Rezoning Transportation Analysis

Petition Number: 2021-125

Date	Description
09-17-2021	First Review (WLB)
11-22-2021	Second Review (AO)
01-25-2022	Third Review (AO)
02-21-2022	Fourth Review (AO)
03-23-2022	Fifth Review (AO)

RZ-3.0

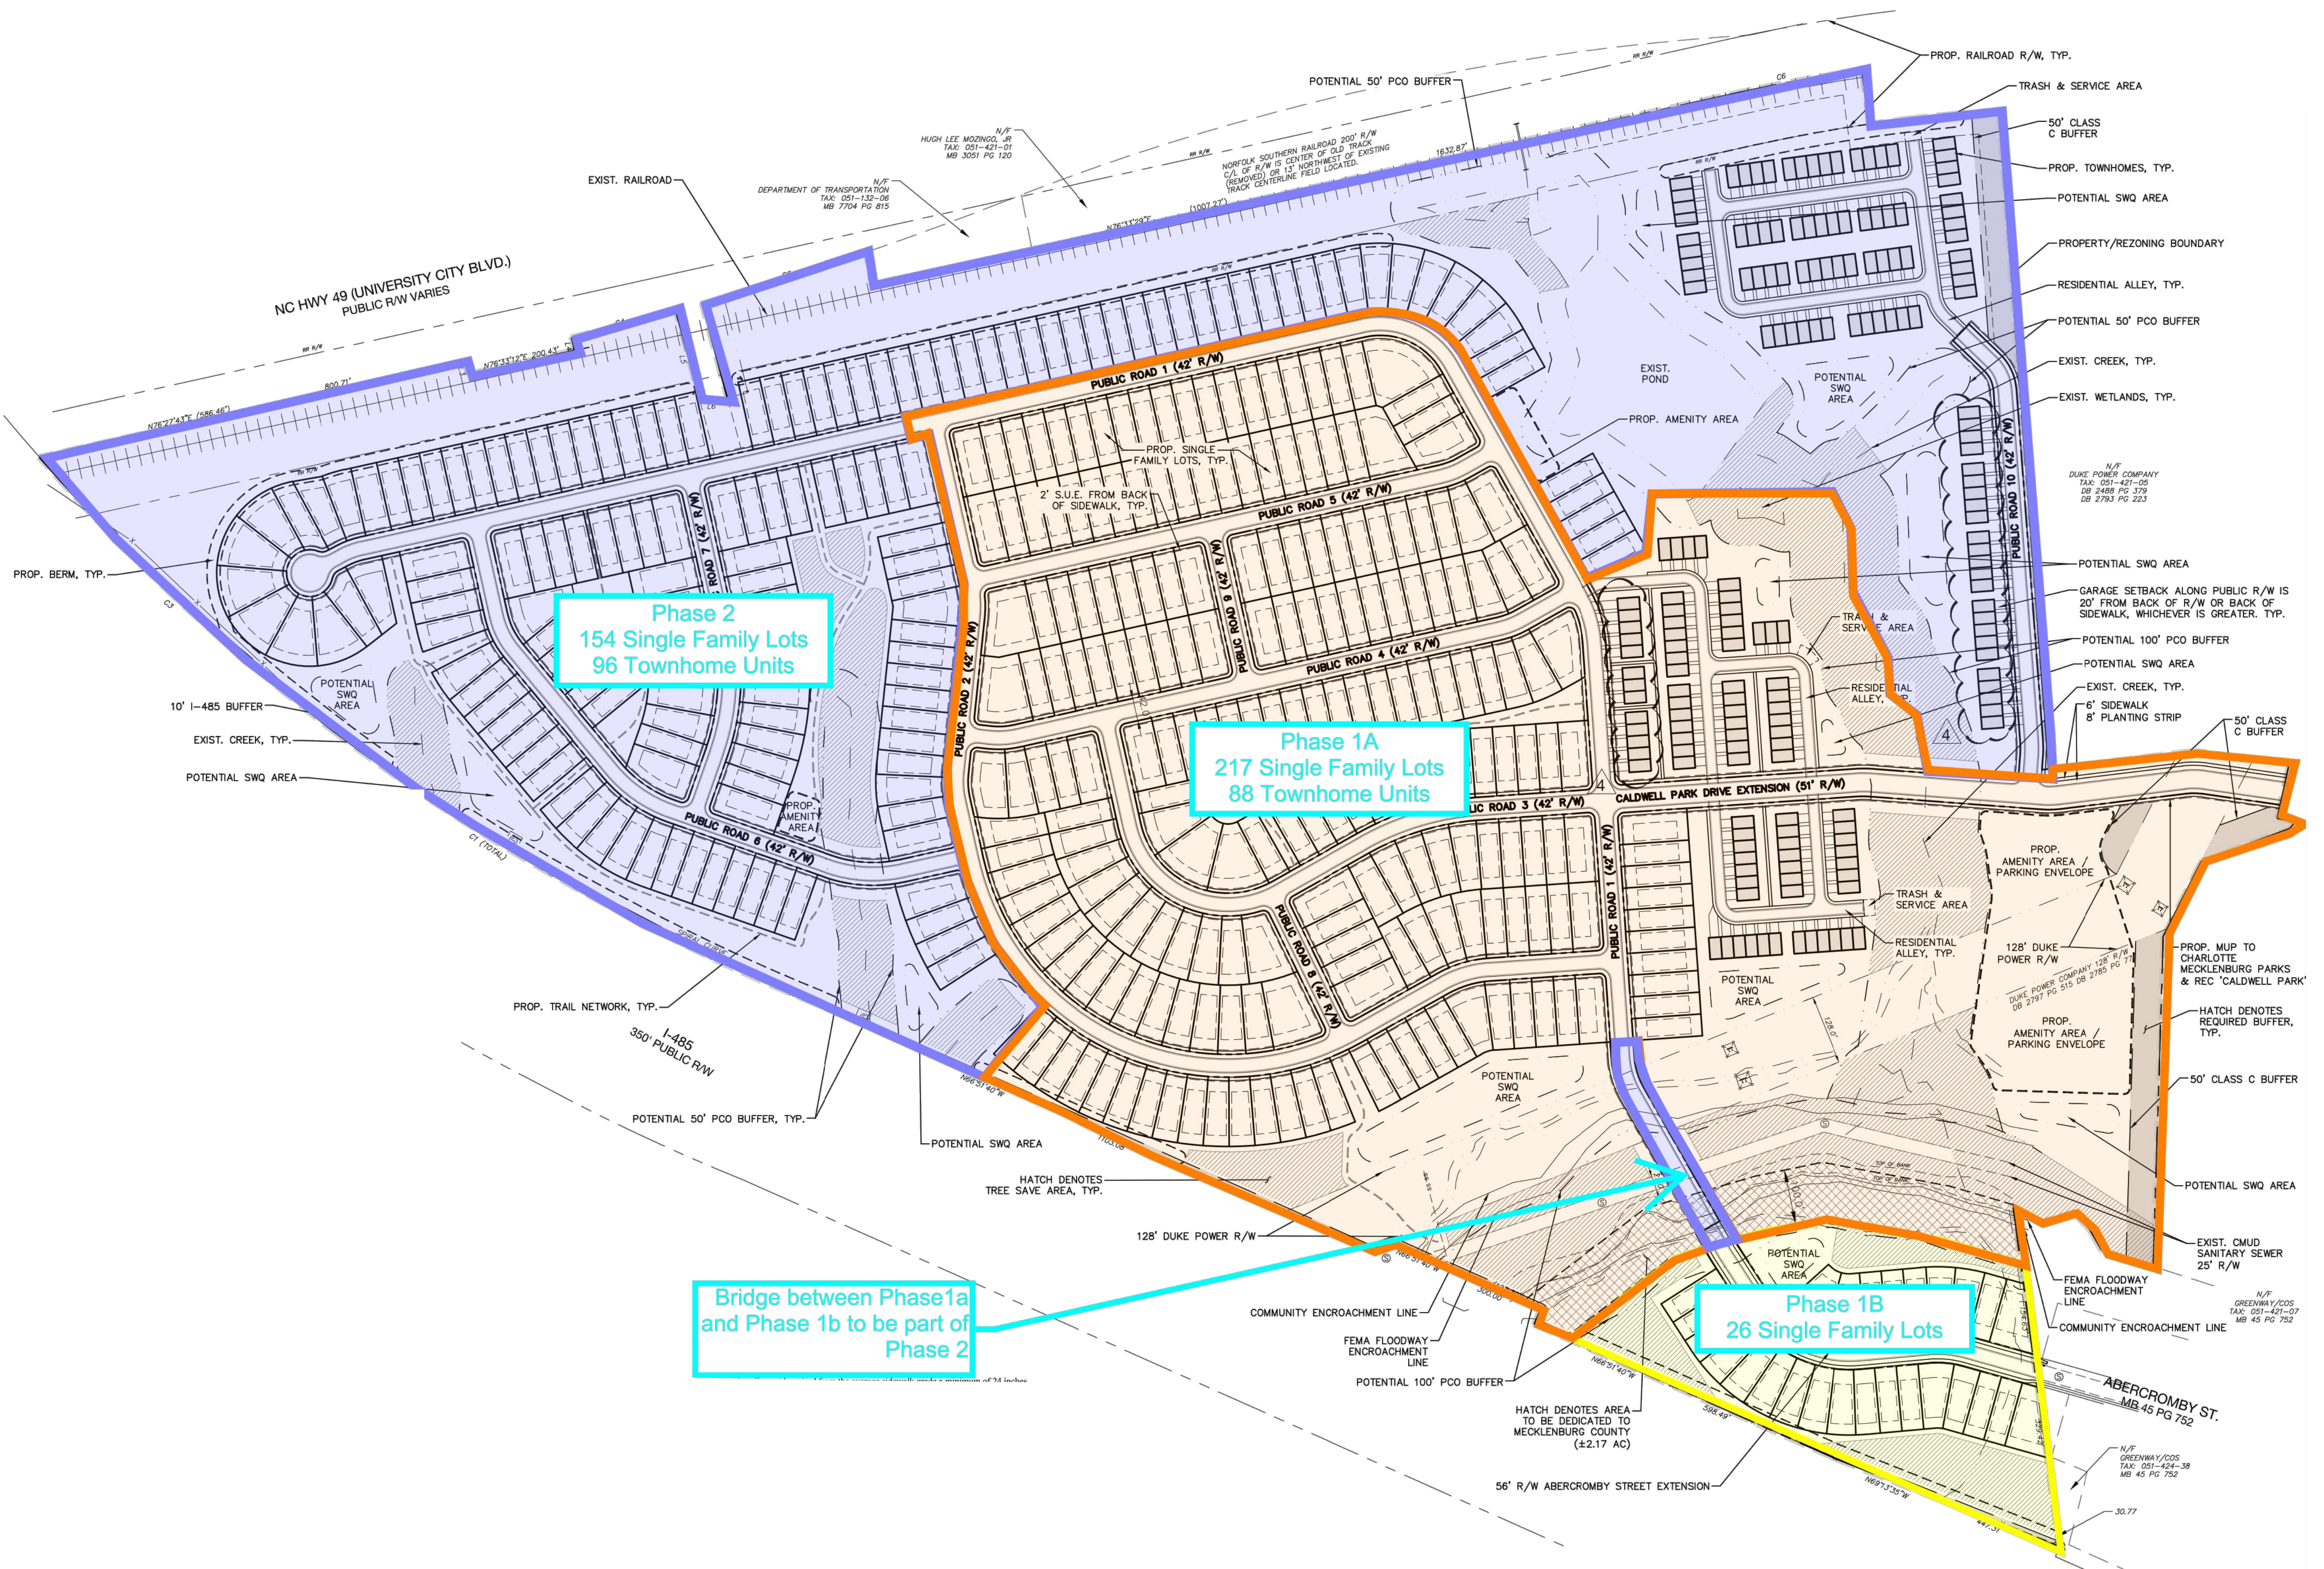
12. **Outstanding Comment from 1-25-22:** Site plan and conditional note(s) revisions are needed to commit to the construction of noise walls between the I-485 right-of-way and the home lots that back to I-485. The wall should be placed within open space to allow for the HOA to maintain it. Site plan and note say a no build area for a potential sound barrier instead noise wall along I-485.
